**WRITTEN SUBMISSIONS OF NFU REGARDING THE NORFOLK BOREAS OFFSHORE WIND FARM
DEVELOPMENT CONSENT ORDER APPLICATION BY NORFOLK BOREAS LIMITED
PLANNING INSPECTORATE REFERENCE NO EN010087**

**SUBMISSIONS OF NATIONAL FARMERS UNION ON THE – EXAMINERS FIFTH WRITTEN QUESTIONS
AND APPLICANT’S ANSWERS TO DEADLINE 14.**

DATE 1st SEPTEMBER 2020

Title:  
Indicative onshore project substation mitigation planting – Scenario 1

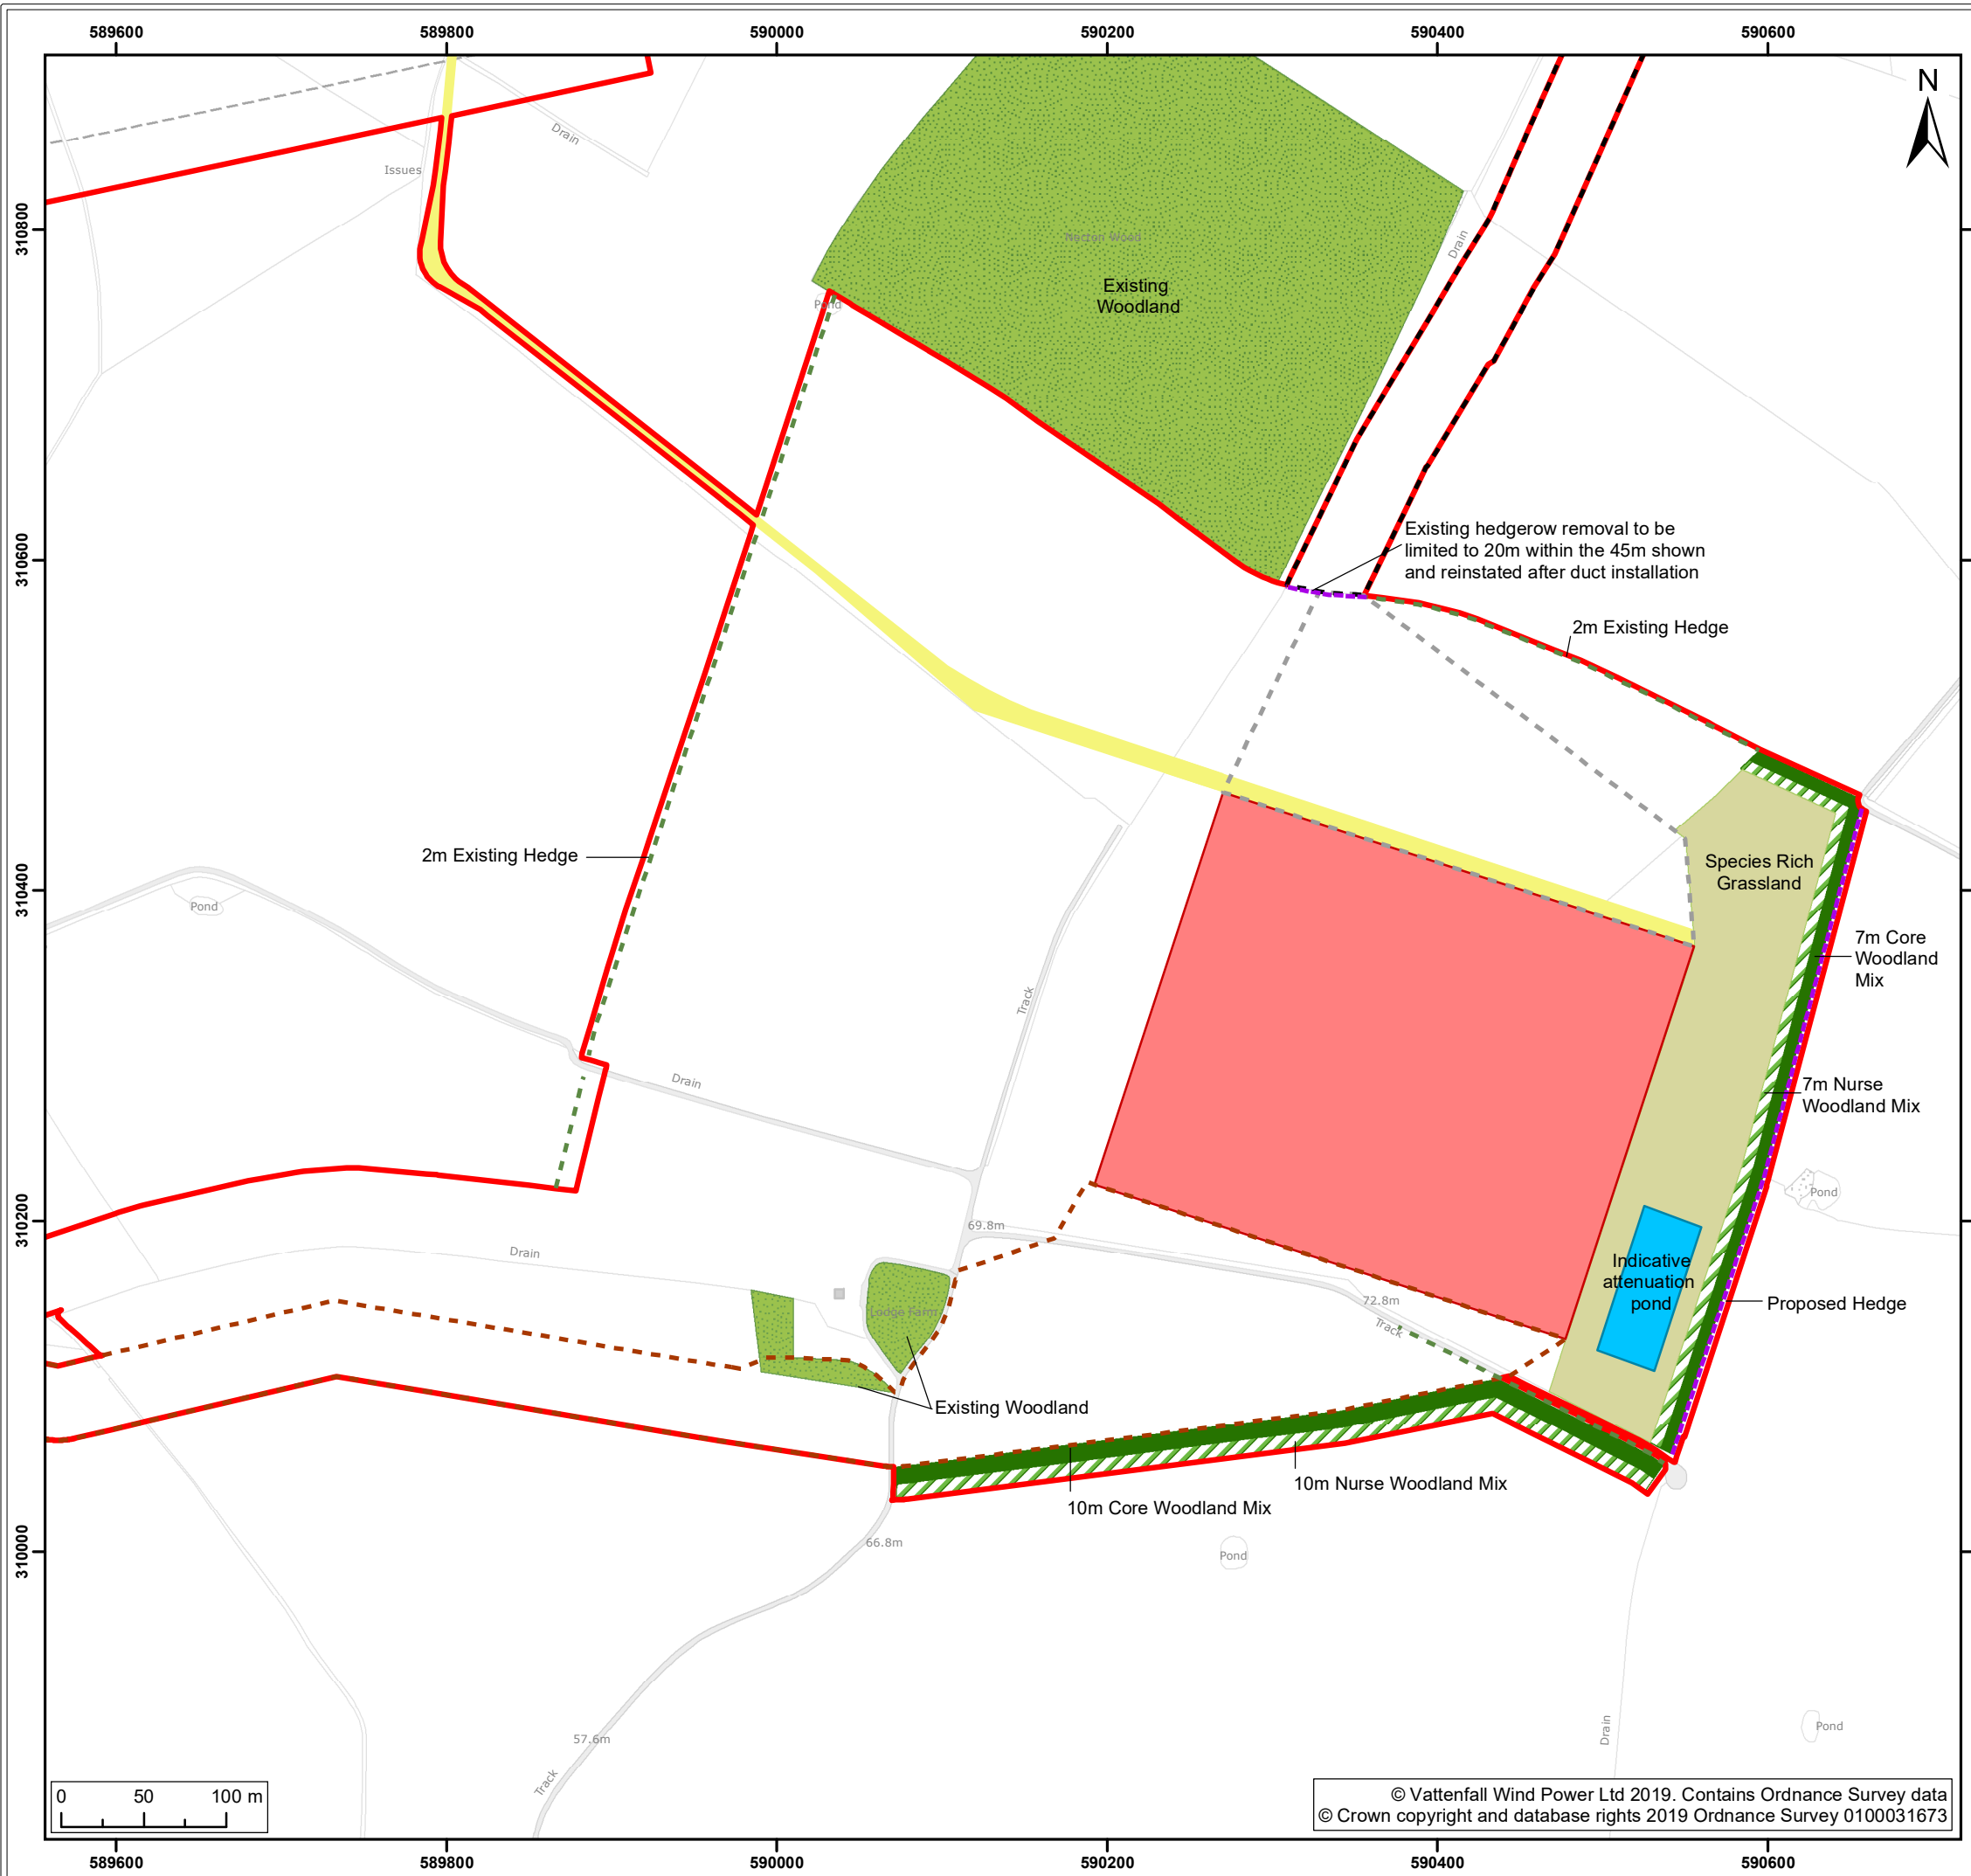
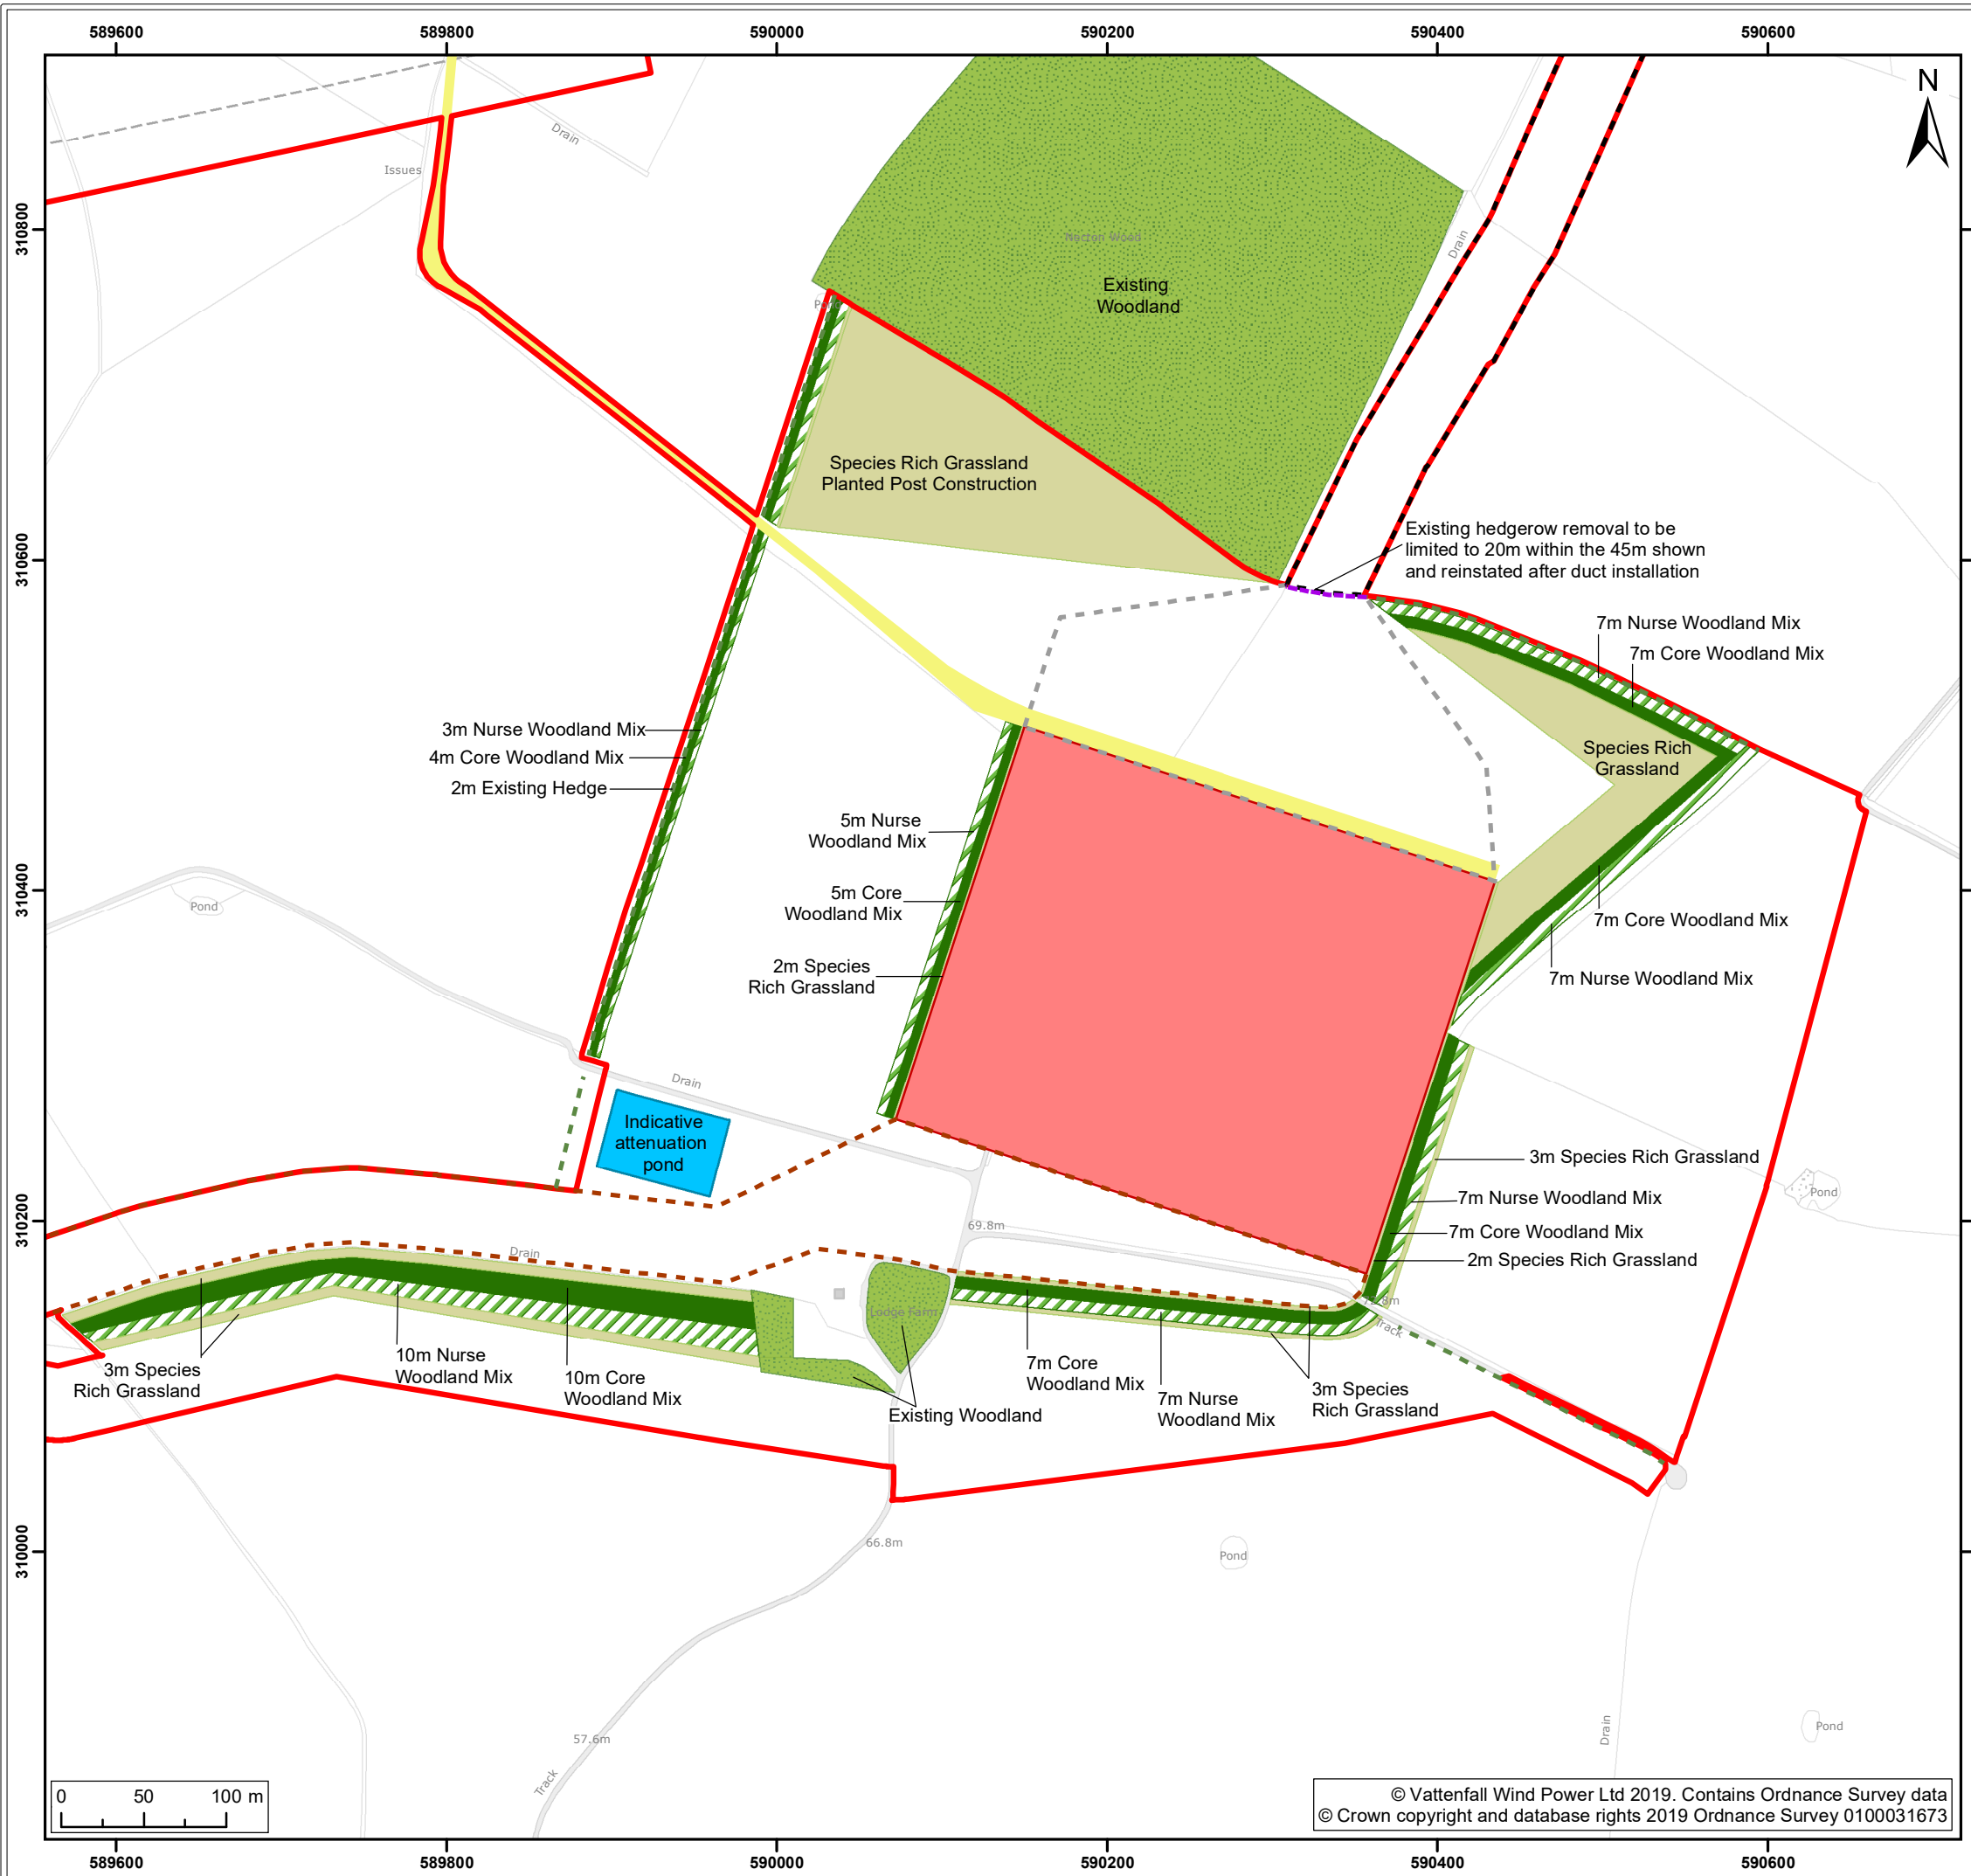
Paragraph 96: The NFU and LIG would like to see that it is stated that Norfolk Boreas must plant trees both 'nurse' and 'core' species which are a mix of whips and well established young stock. It is important that some planting is already established to help the building fit in to its surroundings quicker. Waiting 20 years for the nurse stock to reach 8m in height is too long. When the building is 19m in height nurse stock at 8m is not going to provide substantial screening of the building.

Paragraph 97: It is important the landowners directly affected and the elected local forum have a say in the landscaping works design.

It is stated that the bund could be 2m in height using material which will be excavated to level the site for the building. The NFU and LIG would like further clarification on the width of bunding proposed for the landscape planting and how these groundworks will assist reduce the height of the convertor station.

Planting should also take place on all sides of the convertor building and the width of screening needs to be increased from the specified width of 7m (as set out in OLEMS document 8.7) to 30m to allow for the best possible visual and noise mitigation.
